# **KIRKLEES METROPOLITAN COUNCIL INVESTMENT & REGENERATION SERVICE**

| Reference No:         | <b>2023/62/91426/E</b>                                                                                                                                     |
| Site Address:         | 5, Wells Mount, Upper Cumberworth, Huddersfield, HD8 8XQ                                                                                                   |
| Description:          | Demolition of existing conservatory and erection of single storey rear extension and first floor side extension with partial conversion of existing garage |

Proposed Site Layout
Scale 1:200

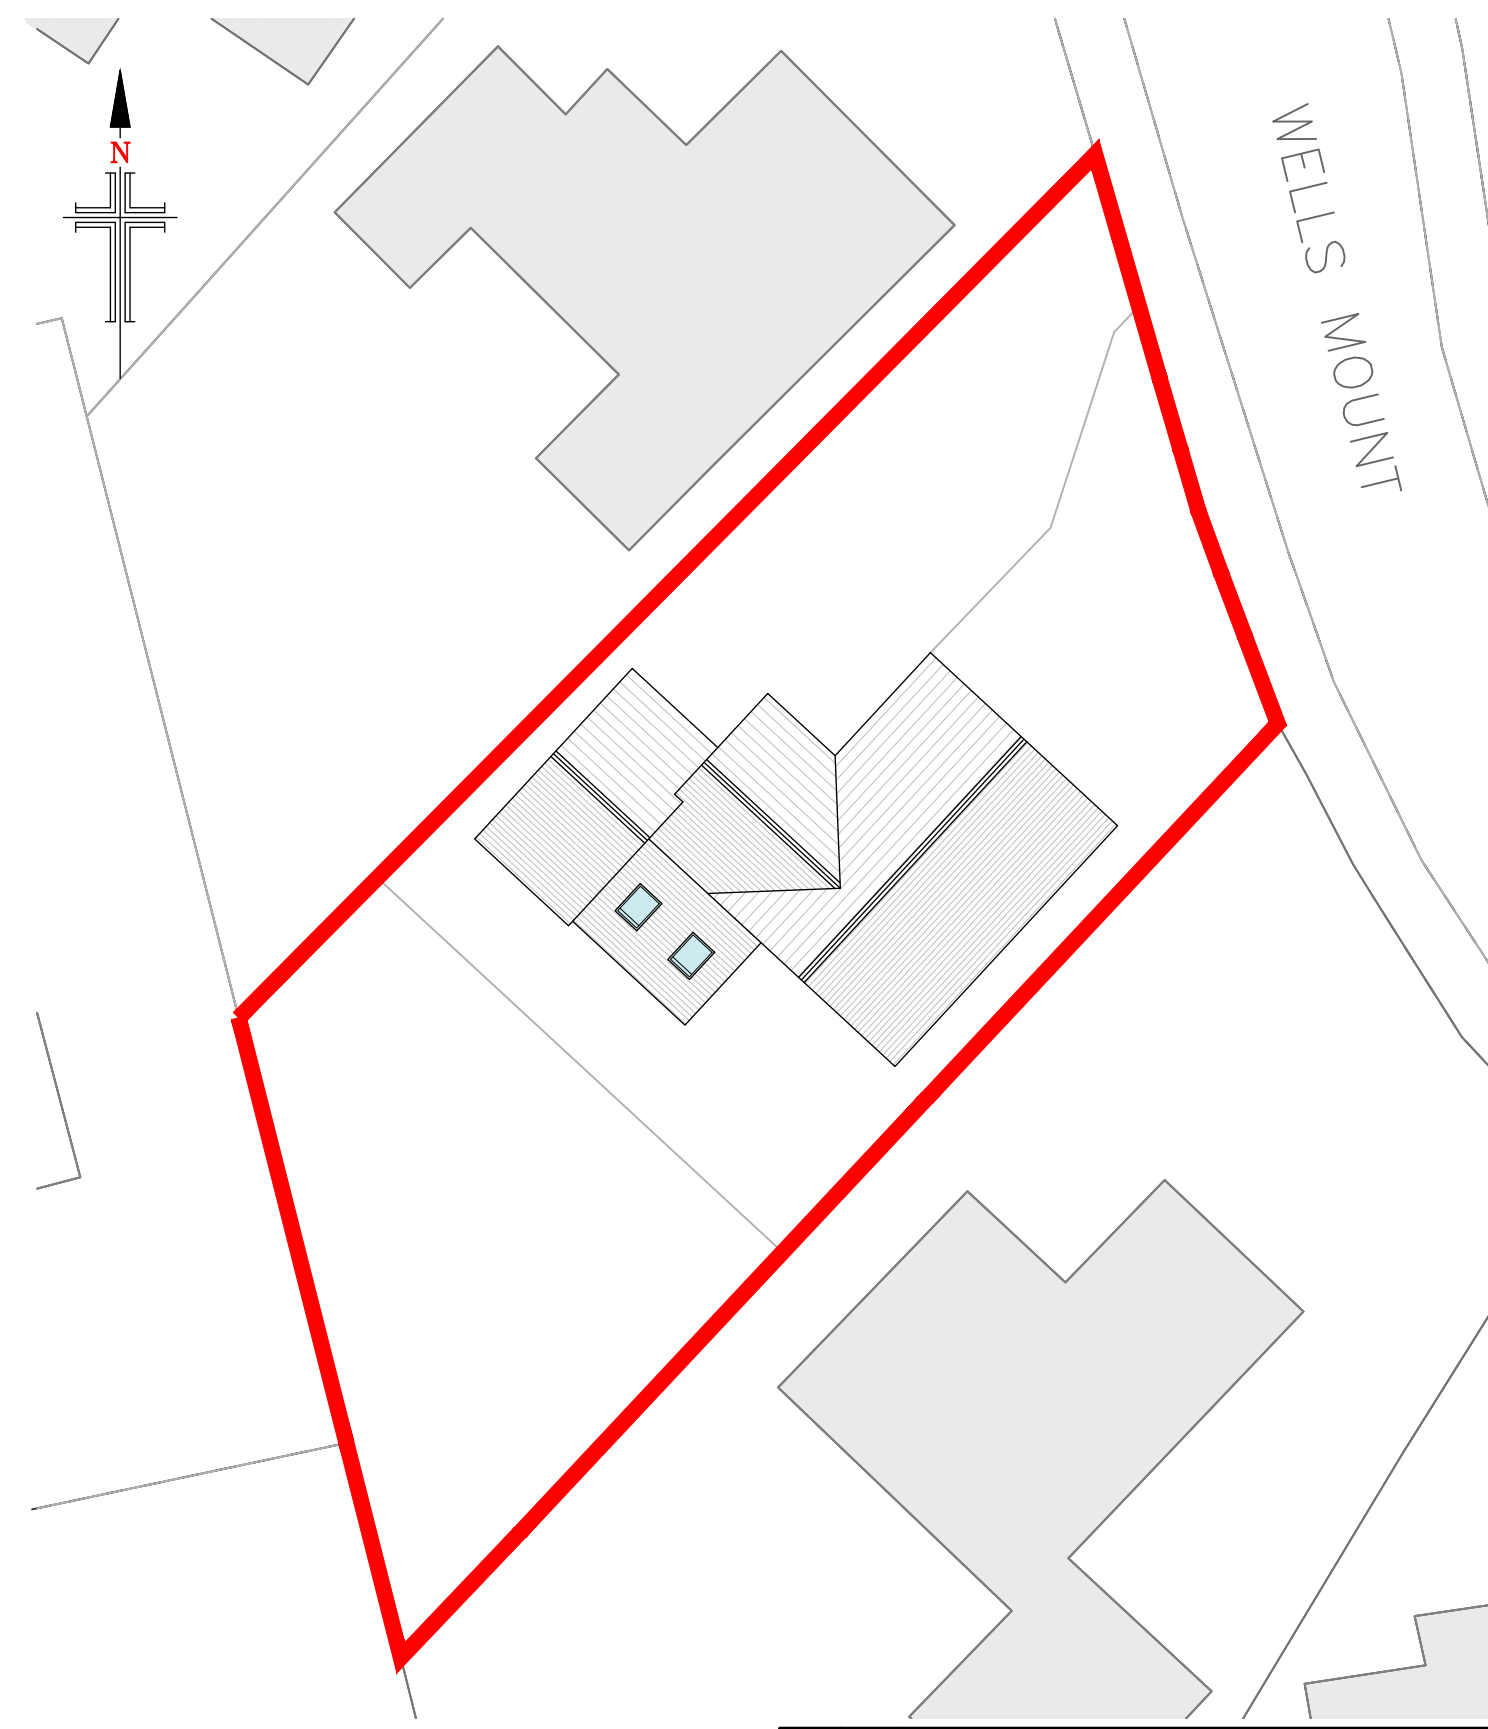
Overshadowing/loss of light: The proposal would extend 8.5m beyond the rear elevation of no.7 and be situated to the south of the dwelling. It is considered that the depth of the proposal coupled with its close proximity, to the neighbouring boundary, would create an unacceptable level of overshadowing for the immediate private amenity space of no.7

Overbearing: As previously highlighted, the alterations to the first floor would extend 8.5m beyond the rear elevation of no.7. It is considered that the proposal would introduce a blank two storey structure closer to the immediate private amenity space of no.7 and a depth of 8.5m. It is considered that this would result in an unacceptable overbearing impact to the occupiers of no.7.

Therefore, it is considered that, the first floor side extension by reason of its scale, proximity to a shared boundary and orientation would result in an unacceptable level of overshadowing/loss of light and overbearing to the private amenity space of no.7 Wells Mount.

Due to the scale, mass and location of the proposal, the extension would create an unacceptable overshadowing and overbearing relationship to the occupiers of no.7 Wells Mount and their private amenity space. The proposal would fail to meet Kirklees Local Plan Policy LP24 in terms of minimising the impact to the residential amenity of neighbouring occupiers and the criteria of the House Extension SPD, particularly KDP 2 & 6 in terms of impact to neighbouring residents and preventing an overbearing impact.
